### Conservation Officer's Report

**Ref. No:** SHD0014/22

**Location:** At the Junction of Santry Avenue & Swords Road, Santry, Dublin occupying the site of the existing Chadwick Builders Merchants

5. Site and structures to be demolished.

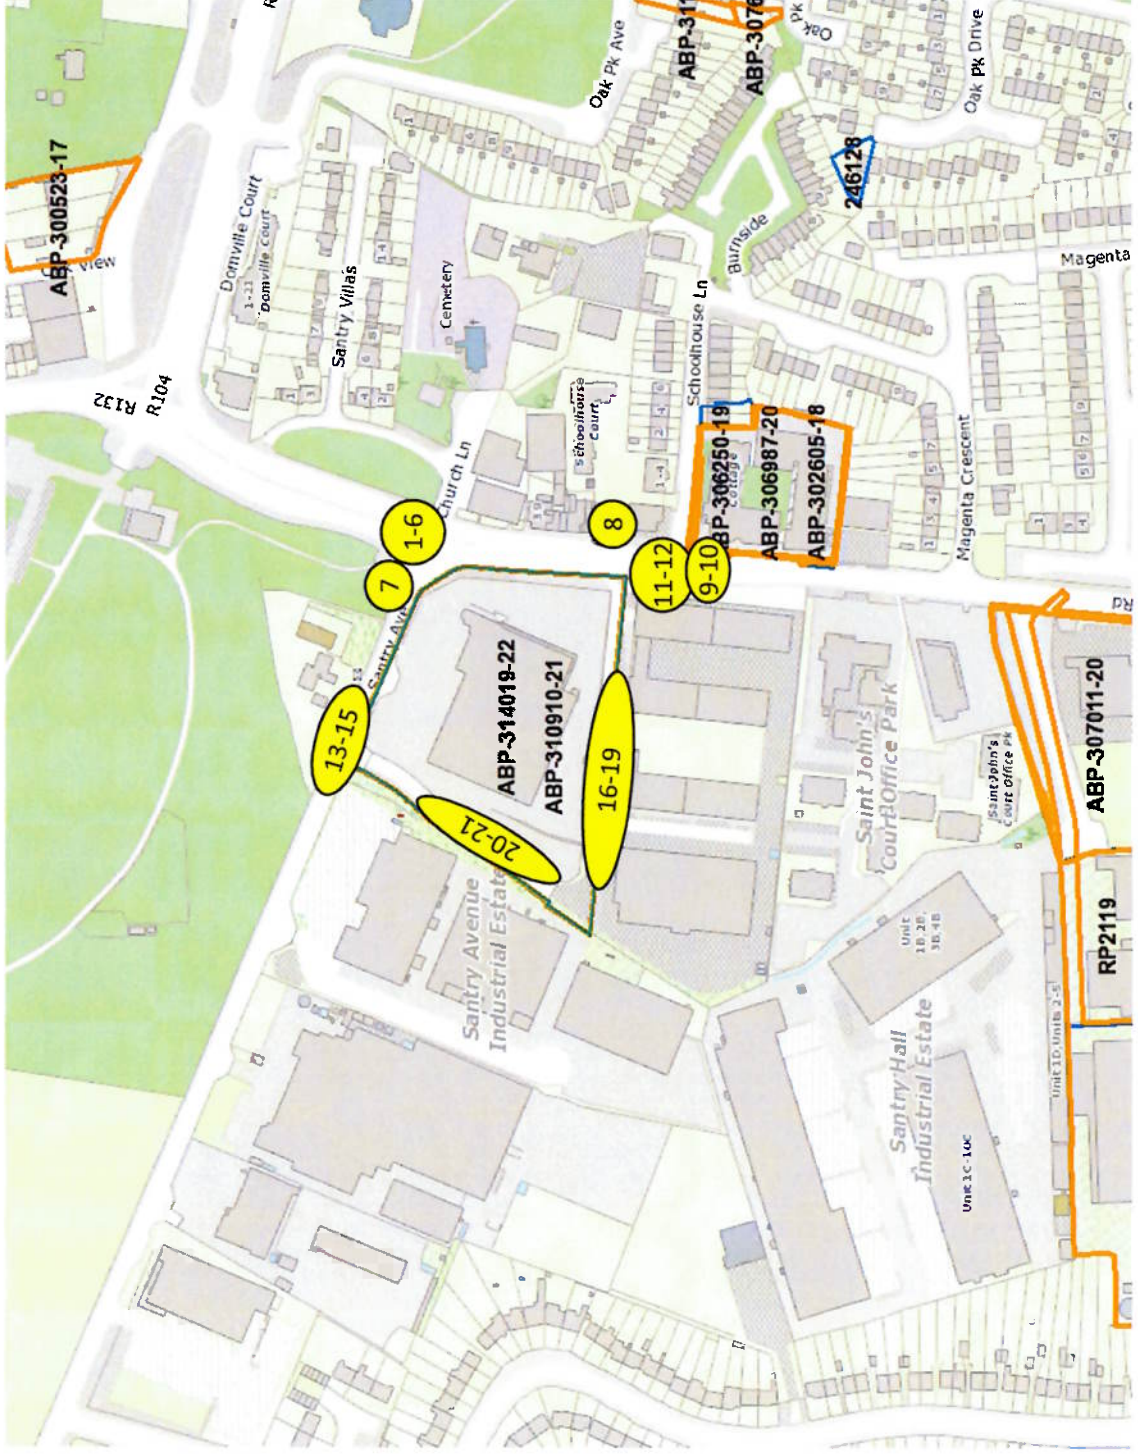
The Conservation Section recommended retention and reuse of the office and showroom block (with rounded bay and tower – but excluding the former multi-bay factory to the rear/west) during the pre-planning consultations with An Bord Pleanála on the proposed development. The applicant's submission does not address whatsoever any option for, or consideration of, the retention of the building as requested at consultation stage. No examination of the possible retention of the office and showroom block has been provided, nor any justification as to why this portion of the building could not be incorporated within the proposed scheme. The Conservation Section notes that the AHIA states that *'the condition of the building is considered fair/good'* adding that there are *'no signs of structural failure or distress'*. The sole reason for demolition provided is *'to allow for optimum site usage the proposal includes the total demolition of the existing buildings on site'*.

The Conservation Section would be supportive of a sympathetic proposal, which retains and incorporates the modernist office and showroom block, which is considered to be of architectural merit and an established and recognisable local landmark on this arterial route into the city, leaving

the majority and remainder of the site available for redevelopment. Whilst it is recognised that this building is not a protected structure the proposed demolition and irreversible loss of this exemplar modernist light industrial/commercial 20<sup>th</sup> century structure is highly regrettable from an architectural conservation and heritage perspective and as such the development proposal cannot be supported by the Conservation Section.
